DRB CASE ACTION LOG

DRB Application No.: 06DRB-01564 (P&F)
Project Name C OFA WATER TREATMENT FACILITY
Agent: Larkin Group NM Inc.

DRB Application No.: 04DRB-01330 (SBP)
Project Name: C OF A, WATER TREATMENT
Agent: Sites Southwest

**PHASE 1
 DIMENSIONED SITE PLAN & UTILITY LAYOUT**

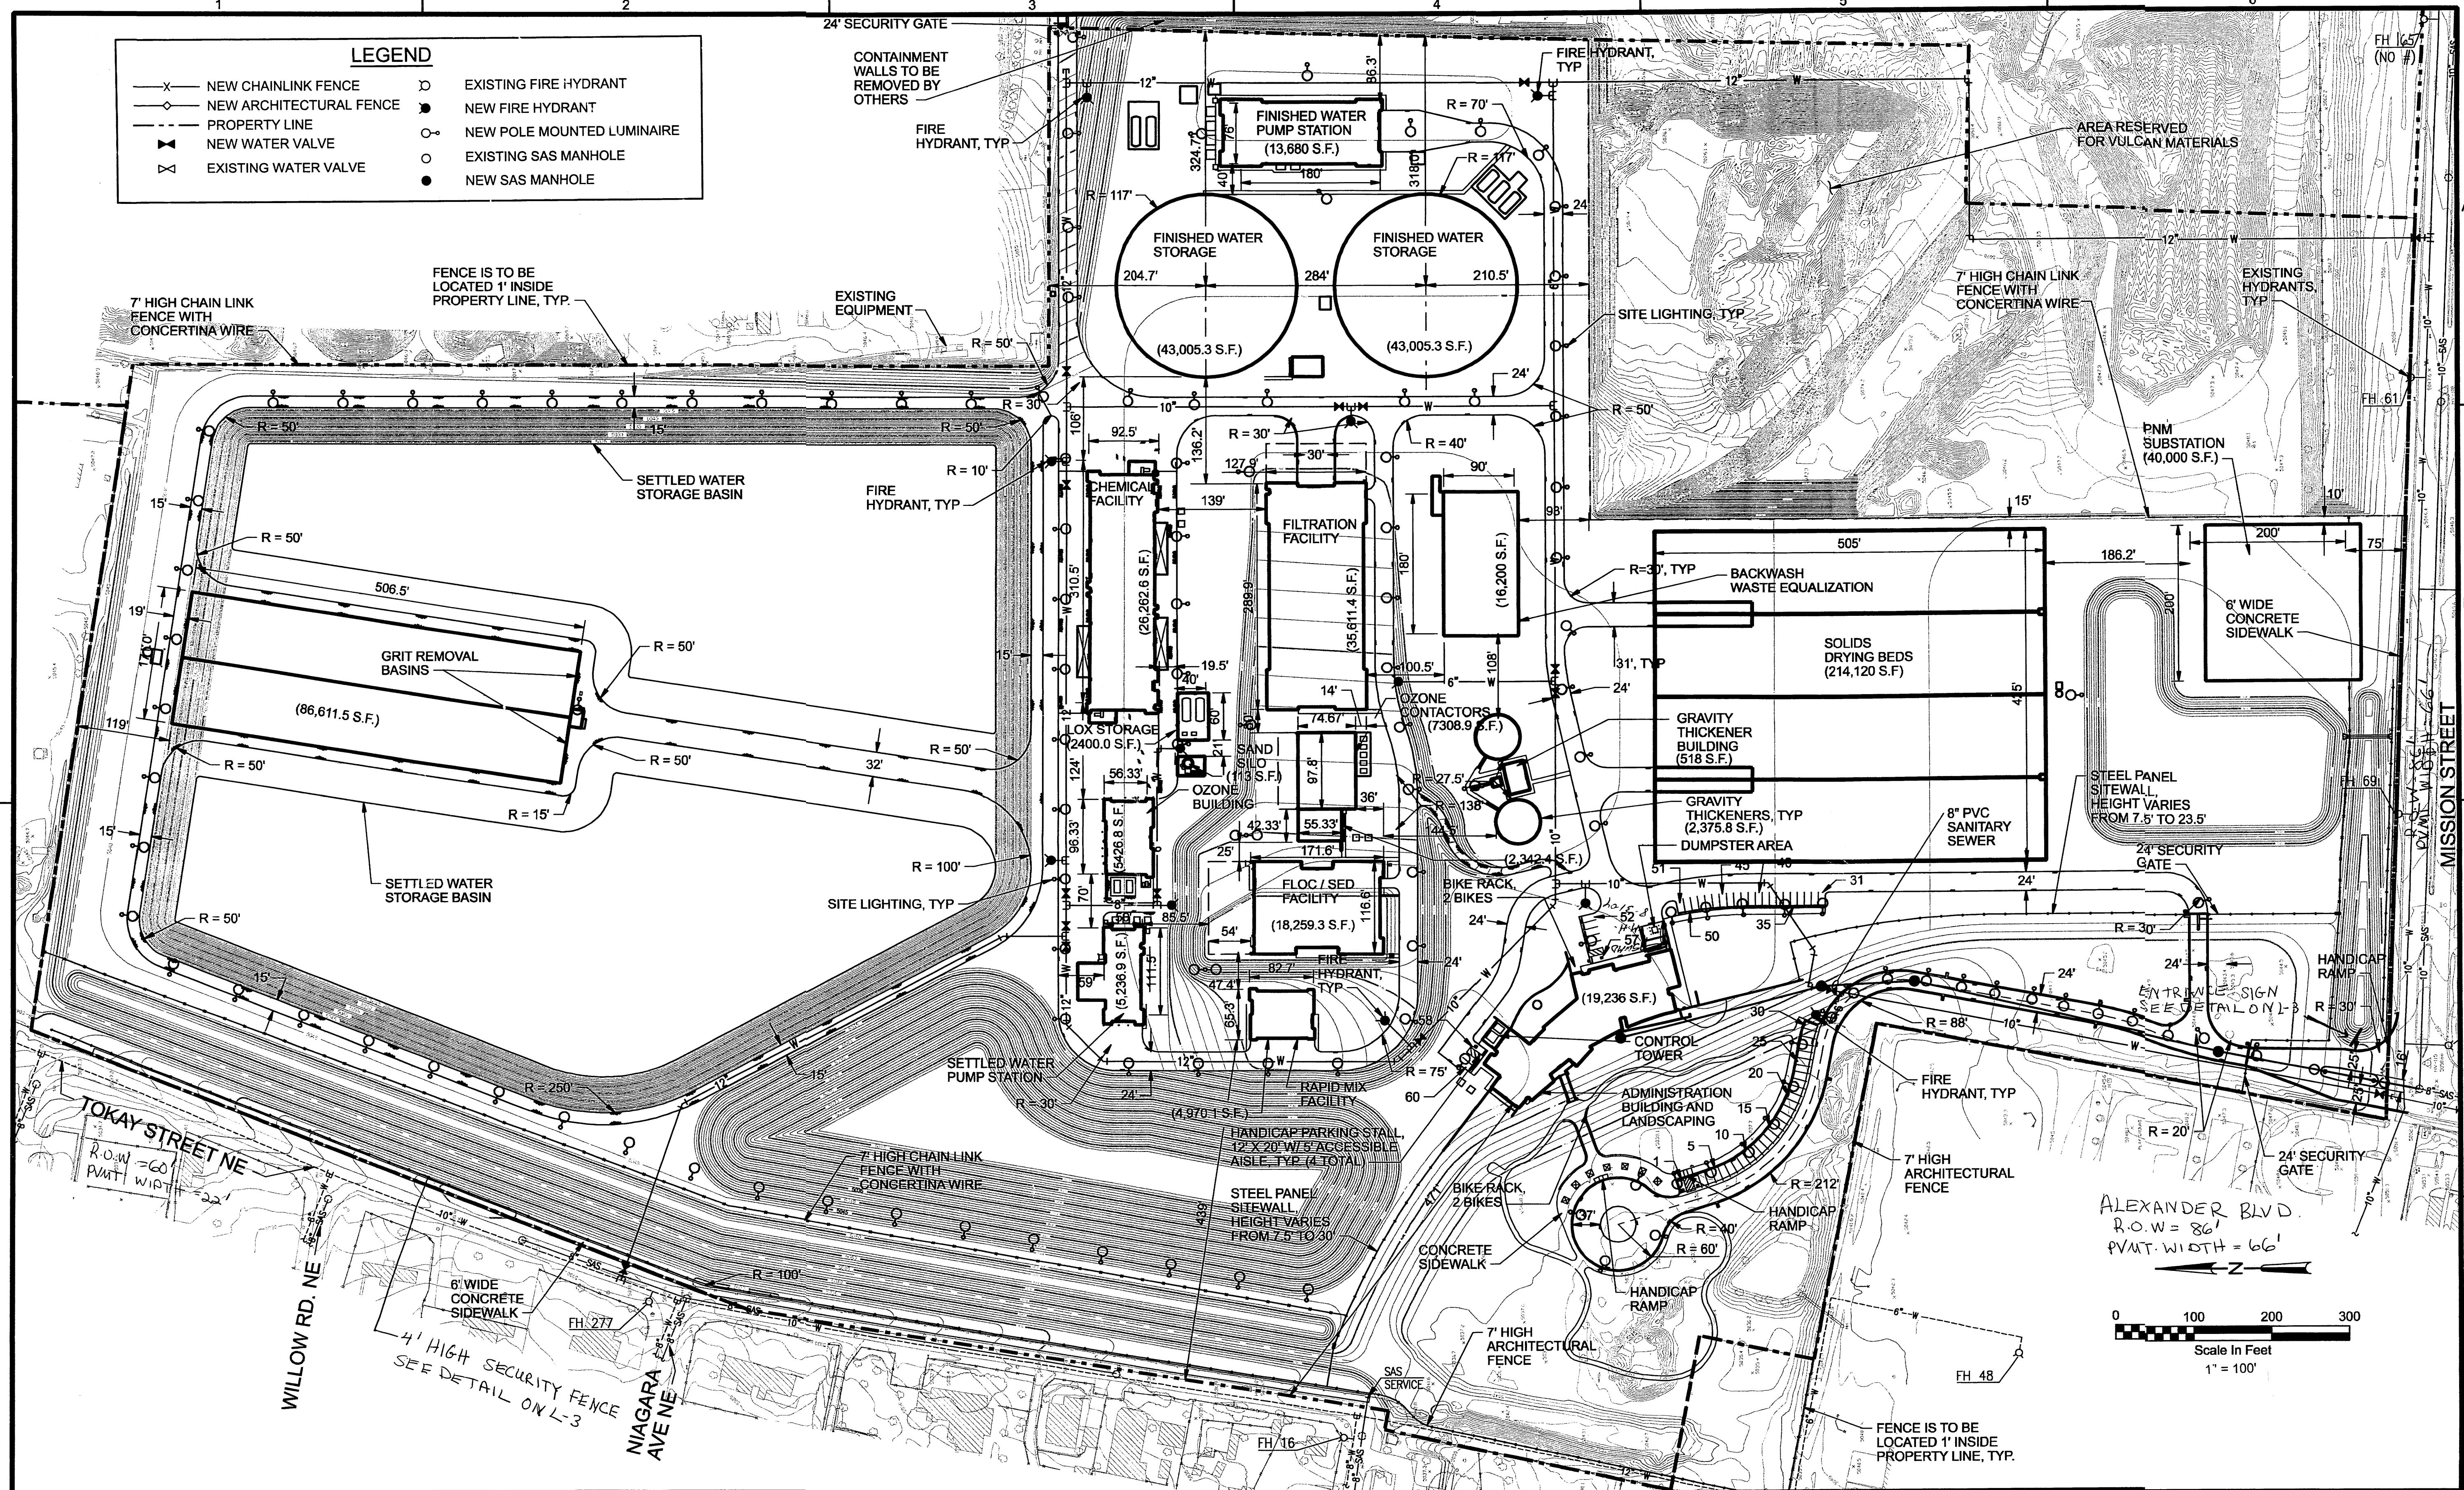
- TRANSPORTATION: - ADA aisles are 5' or 8'
- Need parking stalls dimensioned
- provide sidewalk width thru out project
- provide x-section of how street section (chappell) relates to Right-of-way dedication
